Number	Draft Condition	Comment
<b>General Conditions</b>		
1	A Subdivision Certificate for the development site shall not be released until a site specific chapter in Council's Development Control Plan has been adopted by Port Stephens Council.	PSC to delete.
2	All adjustments to existing utility services made necessary by the development are to be undertaken by the developer at no cost to Port Stephens Council.	Council's position noted.
<b>Building Issues</b>		
3	A report which identifies the satisfactory remediation of all identified site contamination is to be provided <b>prior to the issue of a Subdivision Certificate.</b>	Council's position noted.
<b>Section 94A Contributions</b>		
4	<p>Pursuant to section 80A(1) of the Environmental Planning and Assessment Act 1979 and the Port Stephens Section 94A Development Contributions Plan, a contribution of the cost of development shall be paid to Council, as determined in accordance with clause 25j of the Environmental Planning and Assessment Regulation 2000 and as outlined in Table 1 below.</p> <p><u>Table 1</u> Development Cost and Levy Rate</p> <p>Proposed cost of carrying out the development is up to and including \$100,000 - Nil

TYPICAL CROSS SECTION ONE WAY CROSS FALL ROAD

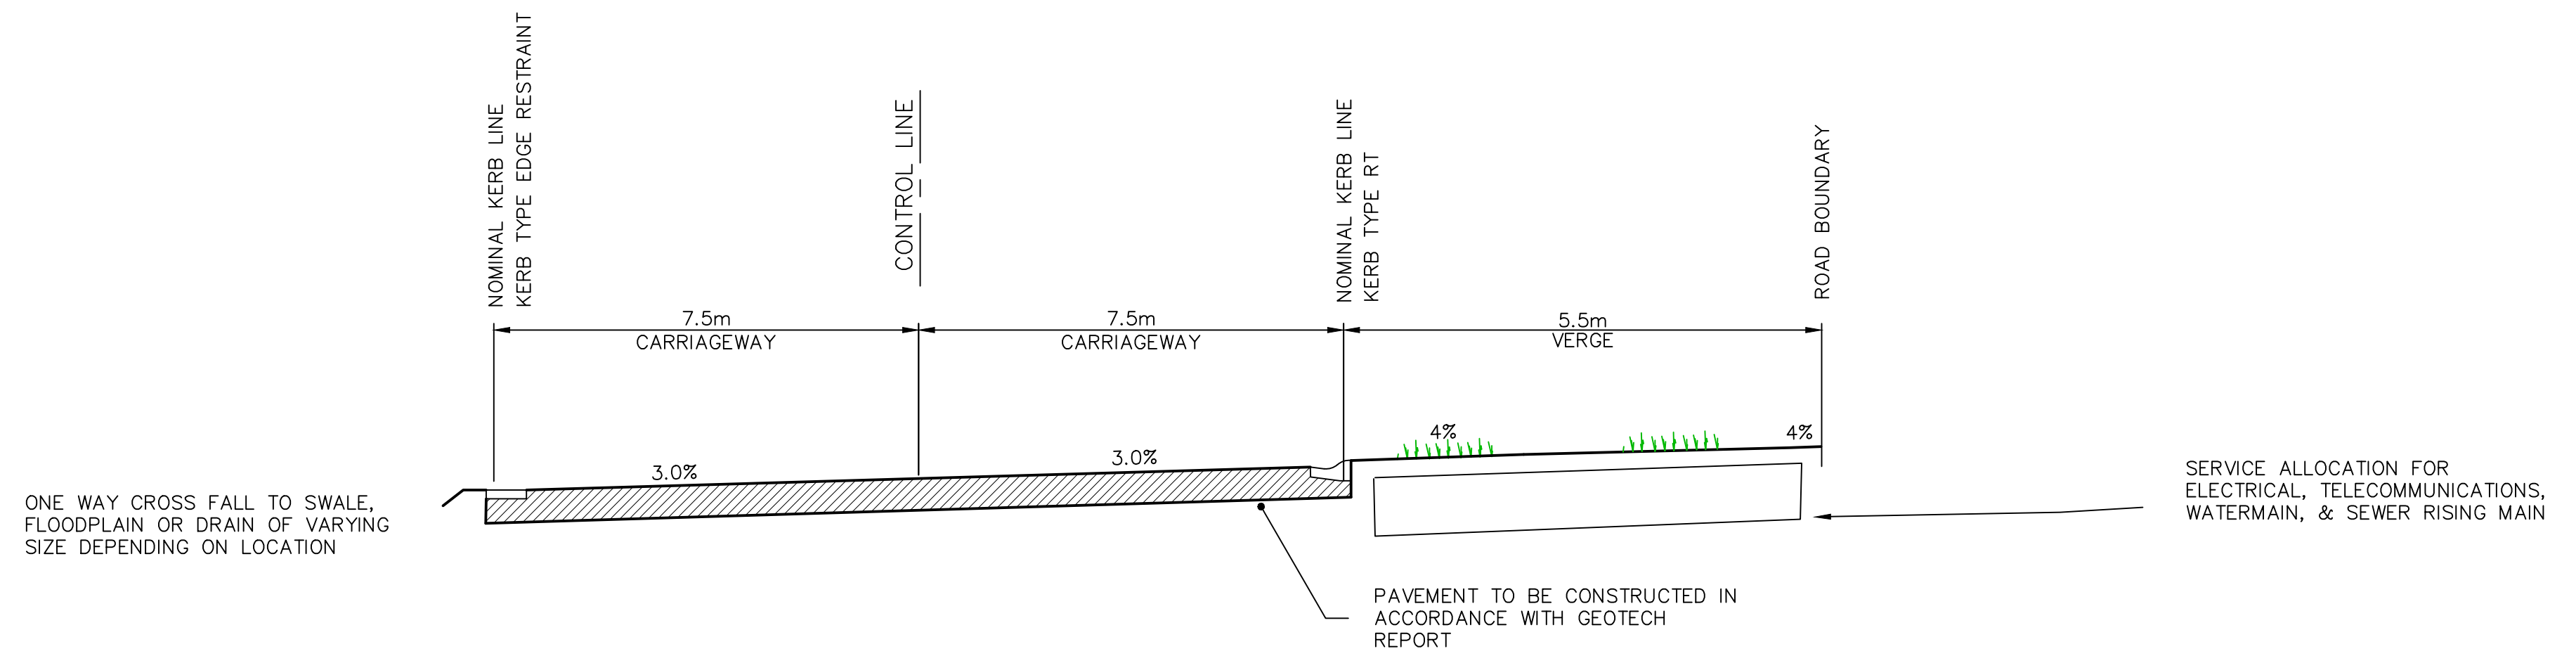
36	All internal roads shall have cross sections that show a 2 way cross fall with the road's crown on the centreline with standard SA kerb on both sides, roads (1 way cross fall are not acceptable). Details shall be submitted to Council for approval <b>prior to the issue of Construction Certificate</b> .	Not accepted. The design criteria from Austroads for water film depths to avoid aquaplaning can be achieved at this site for this road width. Westrac Drive, previously

accepted by Council in 2012 is one way crossfall and it is advantageous wherever drainage reserves lie adjacent. This reduces road ponding, stormwater piped drainage and drainage crossings.
37	Street lighting shall be designed and constructed in accordance with Australian Standards to the satisfaction of Port Stephens Council, design details shall be submitted to Port Stephens Council <b>prior to the issue of Construction Certificate.</b>	Amend condition to 'internal roads lit to PSC standards'.
38	Where roads cross trunk drainage channels, reinforced concrete box culverts with appropriate wing walls, embankment/erosion protection and safety barriers shall designed and certified by a suitably qualified Chartered Professional Structural or Civil Engineer, all materials specified in the design shall be sulphate resistant, details are to be submitted to Council for approval <b>prior to the issue of Construction Certificate.</b> Bridges of any kind are not acceptable.	Council's position noted.
